Application for a non-material amendment following a grant of planning permission.

Loft conversion with dormers to front and rear of roof. New roof over existing rear extension and new enclosed porch	
Reference number:	BN/60/18/HH
Date of decision	19/02/2019

Changing existing and proposed roof tiles to plain tiles in brown

Drawing P01b November 2018 Scale 1:100 & 1:500 @ A3
Planning Drawing - Ground Floor & Block Plan & Elevations

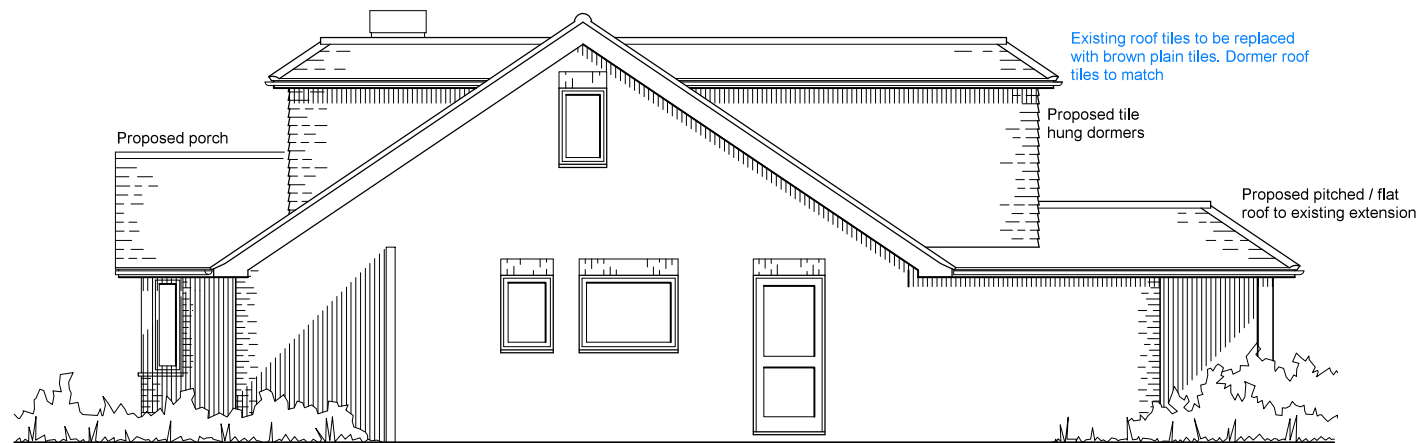
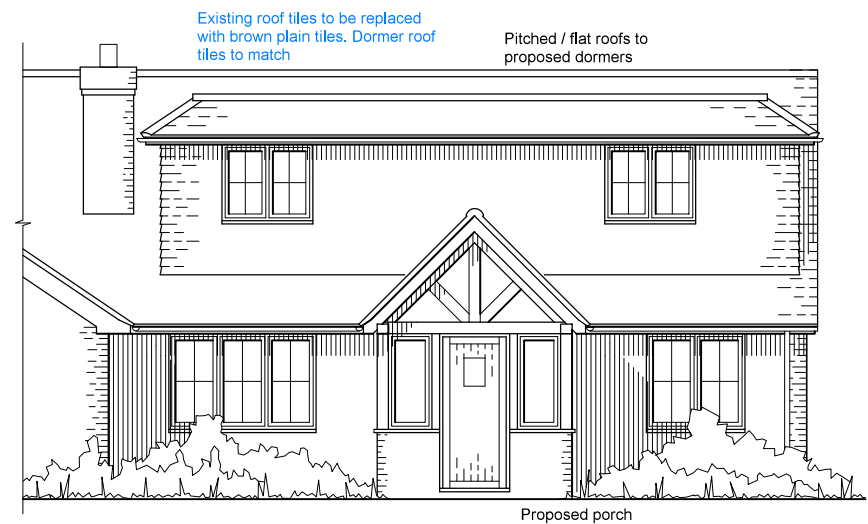
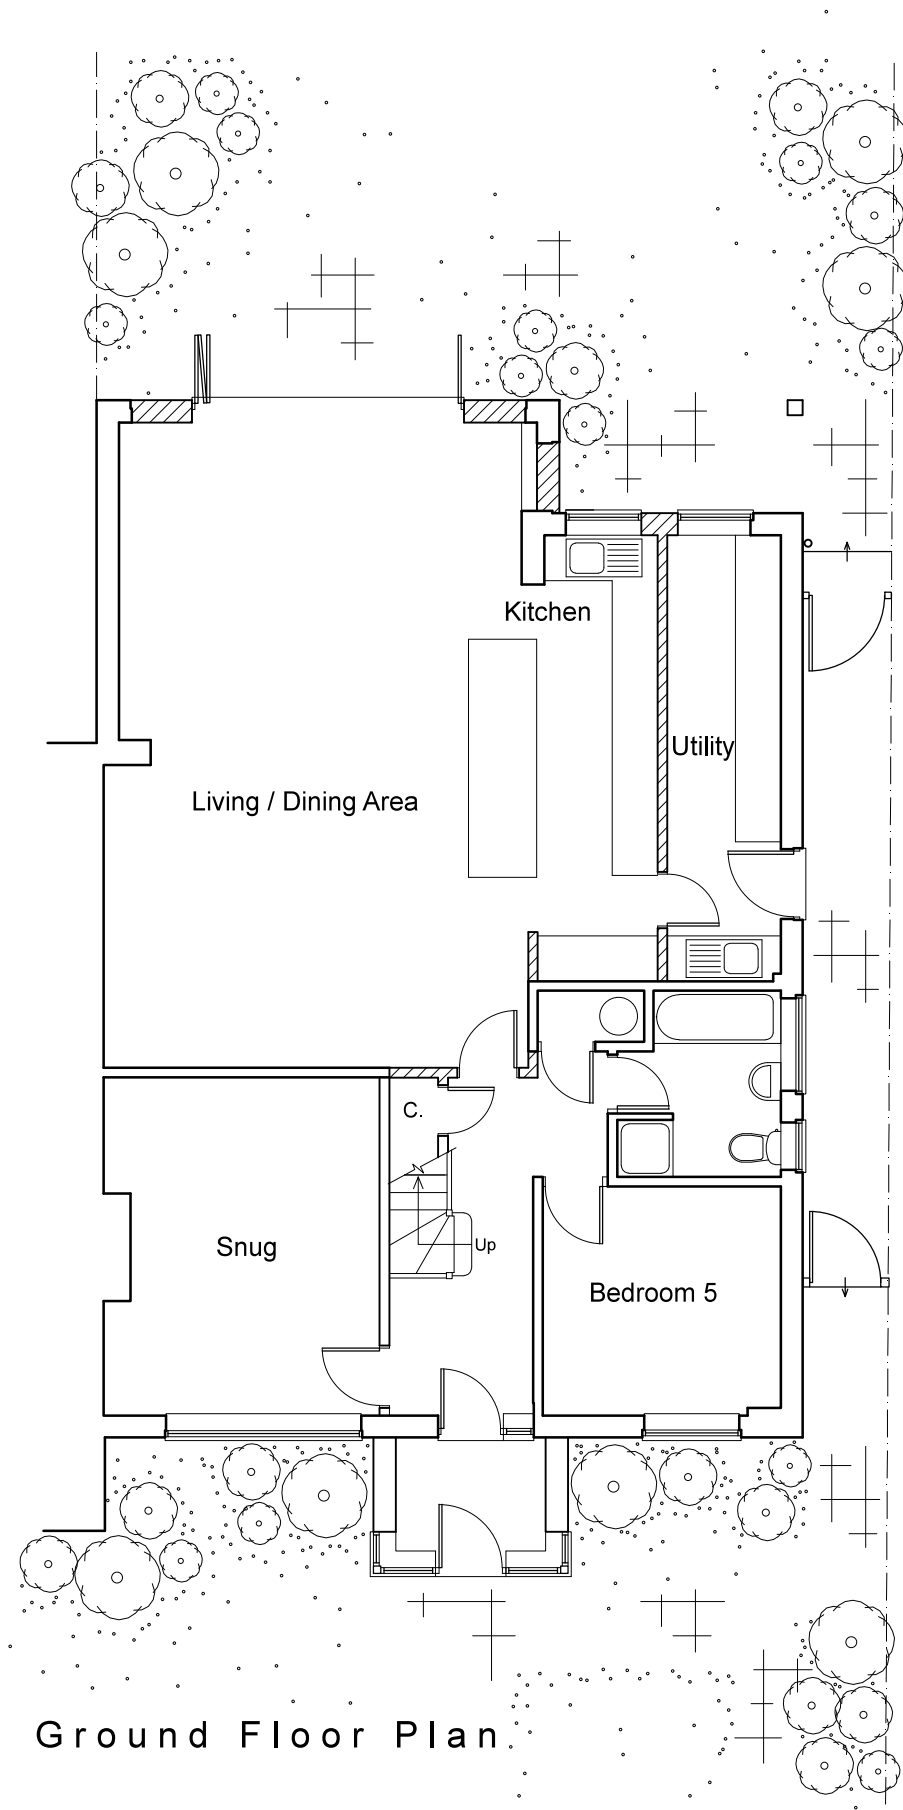
Drawing P01a
Drawing P02a

Drawing P01b
Drawing P02b
